Recommendation Report for Planning Permission for Works or Extension to a Dwelling

REF NO: FG/28/19/HH

LOCATION: 33 Downview Avenue
Ferring
BN12 6QW

PROPOSAL: Conversion of attached garage to habitable space, single storey rear extension, new french doors to rear elevation & replacement of existing flat roof with new pitched roof at rear.

Rev	Date	By	Description of revisions
Client			
Mr and Mrs J Pearson			
Project			
33 Downview Avenue Ferring West Sussex			
Drawing Title			
Proposed Ground Floor and First Floor Plans			
Scale	Drawn By	Date	Size
1:100		Jan 2019	A3
Engineer		Approved	
Drawing No			Revision
A2019.005

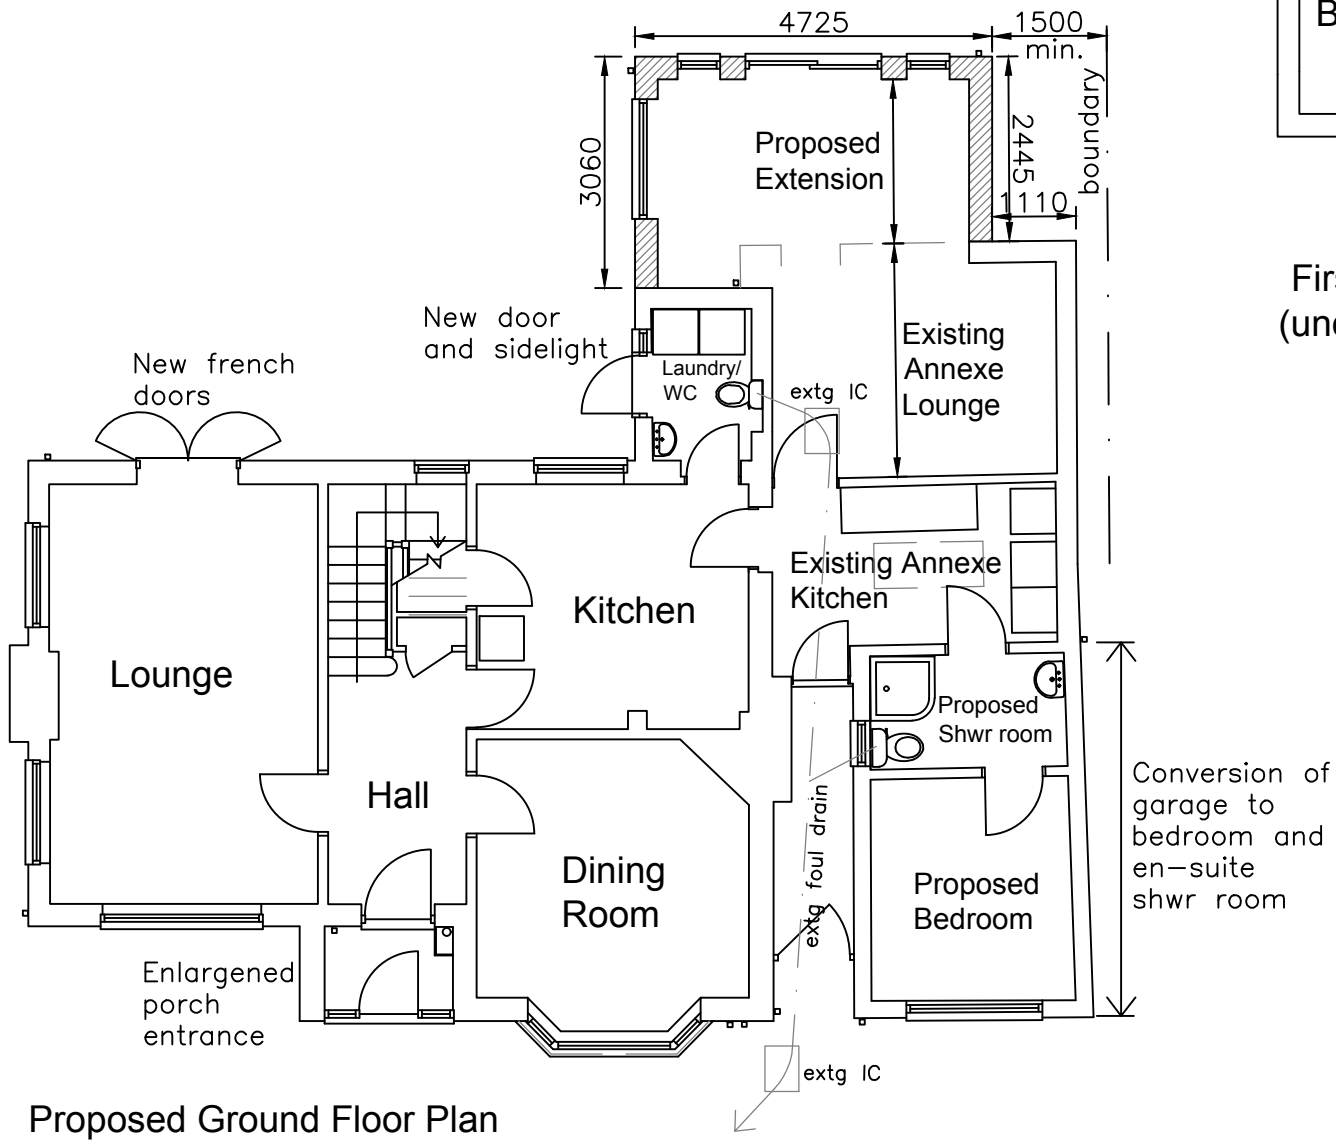
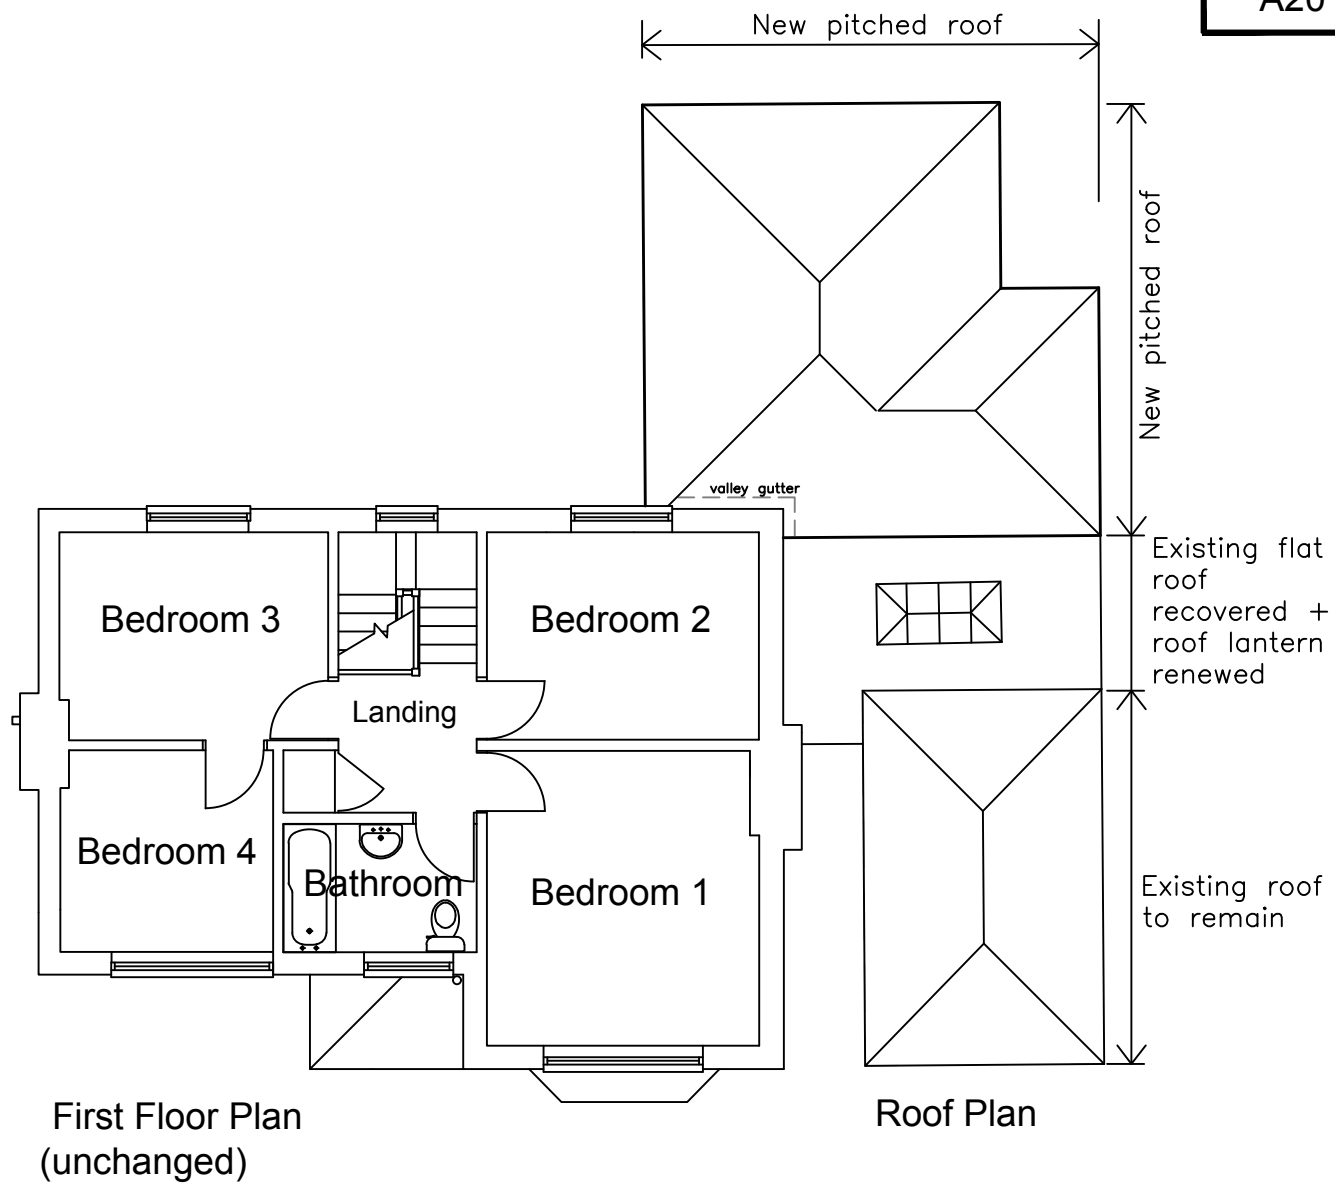
The proposed development is not considered to result in any significant loss of light to neighbouring dwellings. This is because the aspect of the proposed development sited closest to the neighbouring property does not change in height, as it is at eaves height, which is 2.3m. Resultant of the separation distance of approximately 3.8m, and the aspect of the development, the application is considered to be acceptable in terms of impact on neighbouring dwellings. It is noted that the proposed development involves changes in the fenestration of the host dwelling, however, none of these changes are considered to result in any significant loss of privacy to adjacent occupiers, in that all of the openings added are at ground floor level, and therefore provide no views that are currently unavailable from the

Rev	Date	By	Description of revisions
Client			
Mr and Mrs J Pearson			
Project			
33 Downview Avenue Ferring West Sussex			
Drawing Title			
Proposed Elevations			
Scale	1:100	Drawn By	Date
Engineer		Approved	Jan 2019
Drawing No			Revision
A2019.006

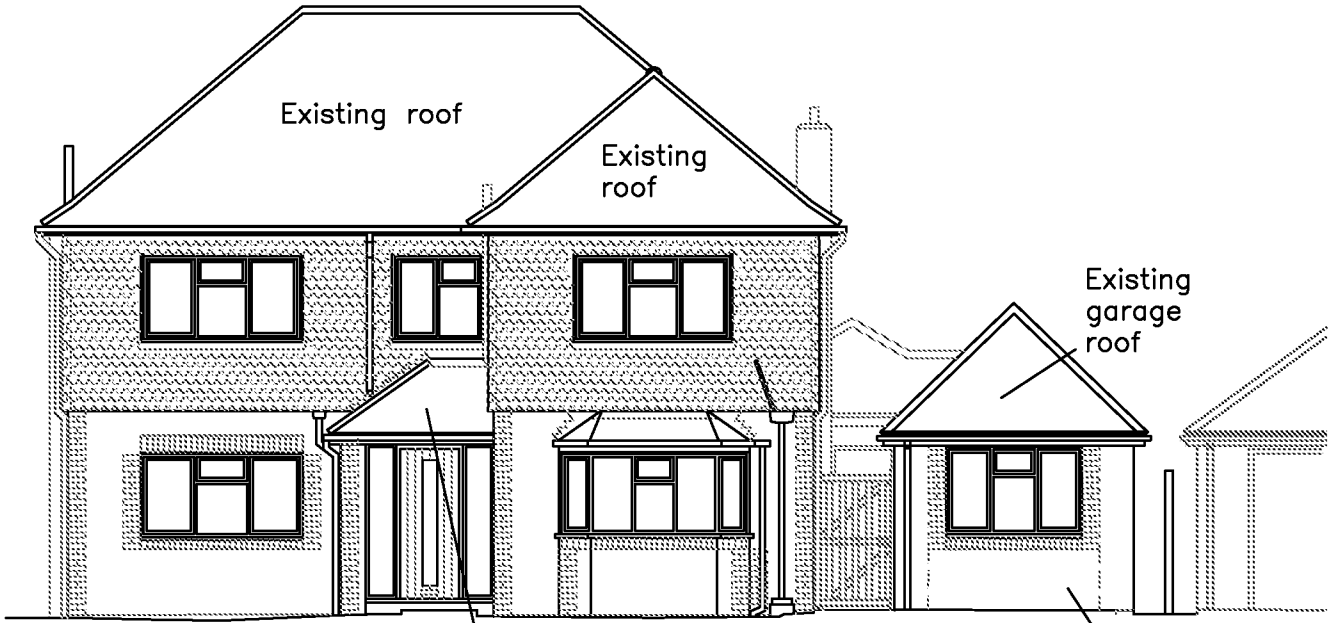
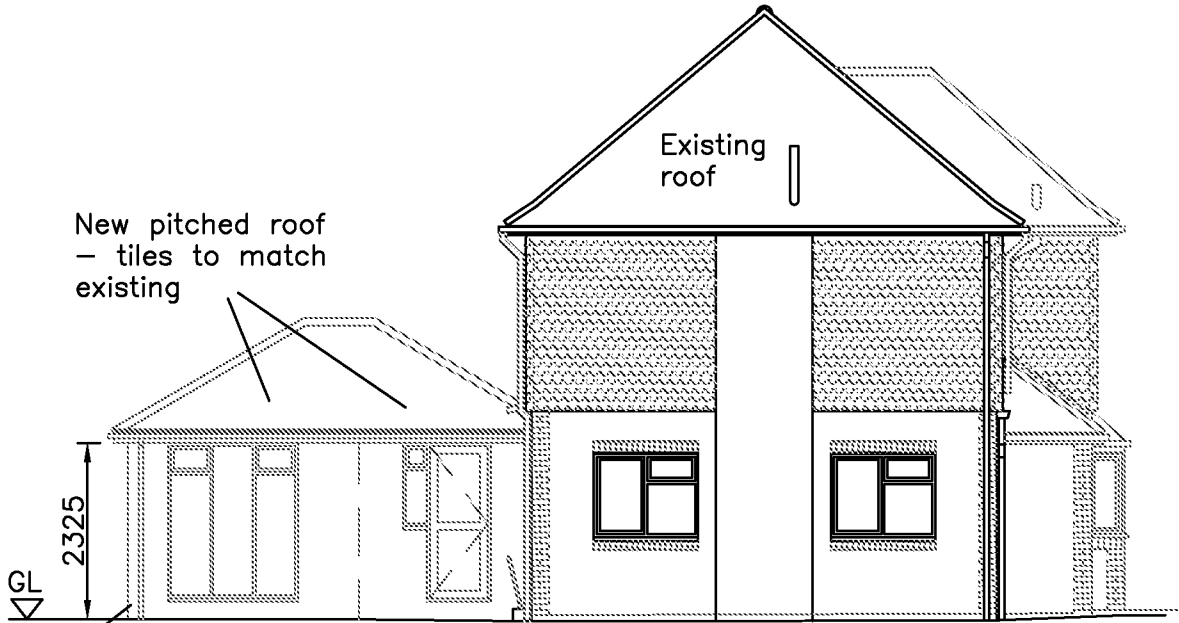
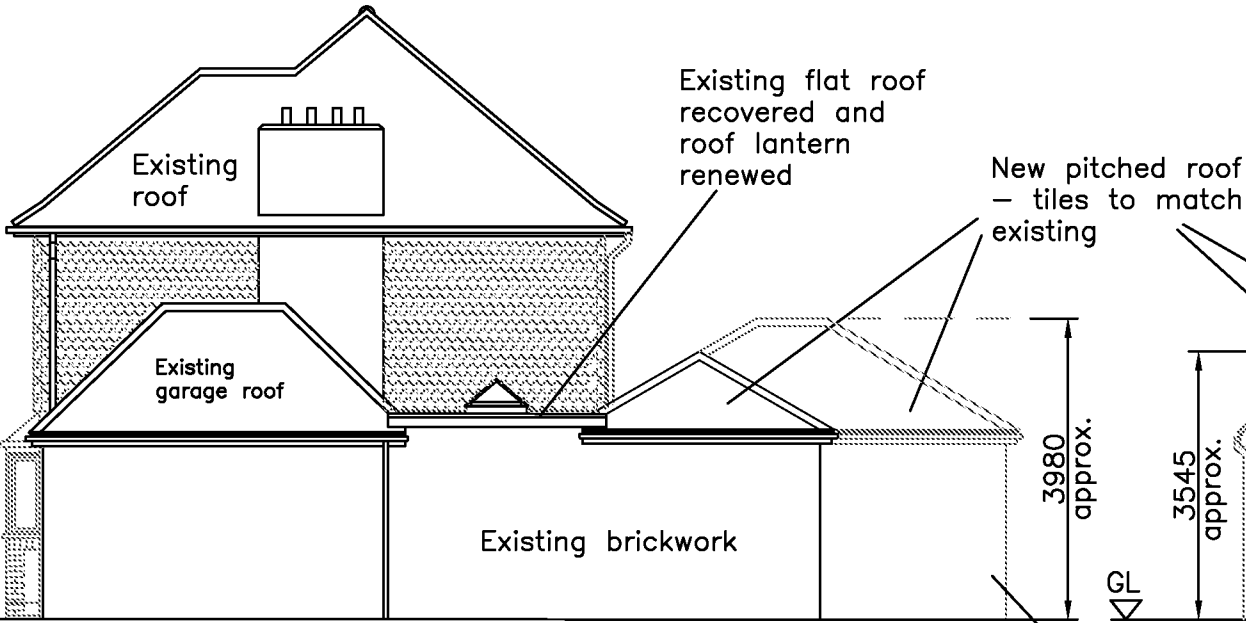
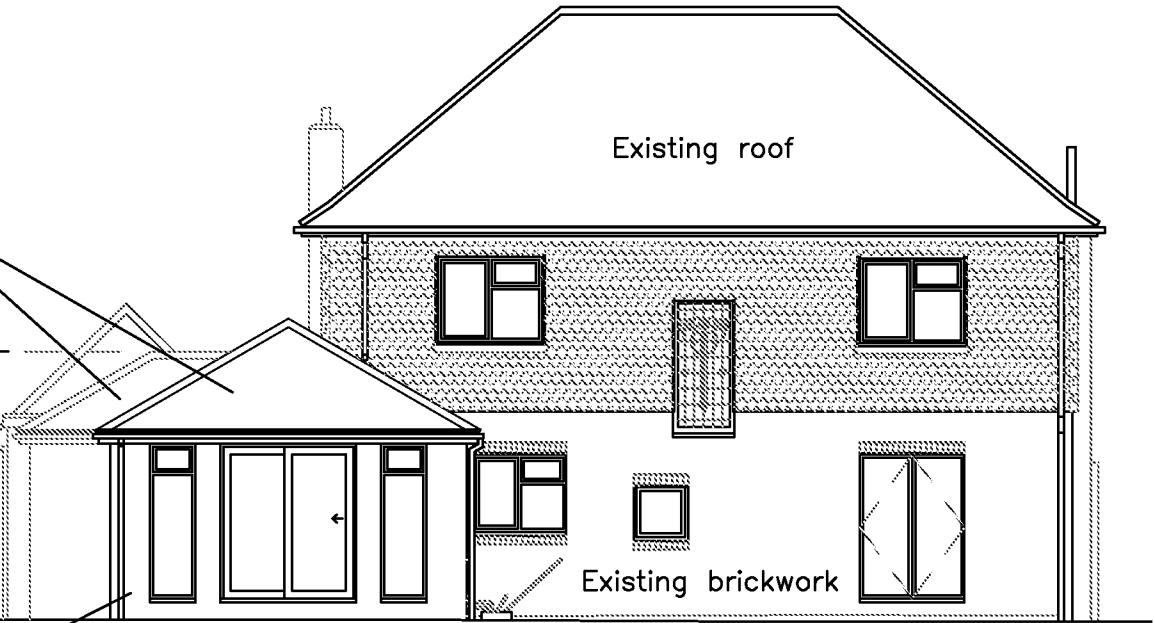
The majority of the alterations relating to the conversion of the garage are internal, and the main visual change will be that the aspect of the building that faces the street scene will have alterations to its fenestration. This is because the existing garage door will be bricked up, and replaced with a window with bricks below. Whilst this would cause the garage to appear different to the adjacent properties to the West, however, it is not considered so significant a change that the application should be refused.

The proposed single storey rear extension is considered to be a sympathetic and subservient addition to the host dwelling. Whilst it is noted that it has a maximum ridge height of approximately 3.98m, it retains the same eaves height of the existing rear elevation. As a result of the siting of the development, and the roof of the garage, there are very few views available of this element of the proposal. The replacement of the rear flat roof with a pitched roof is not considered to have an significantly harmful impact upon the character of the host dwelling, or the wider locality. It is also considered to respond well to the context of the other proposed development, in that it matches the same roof slope angle as this element of the proposal.
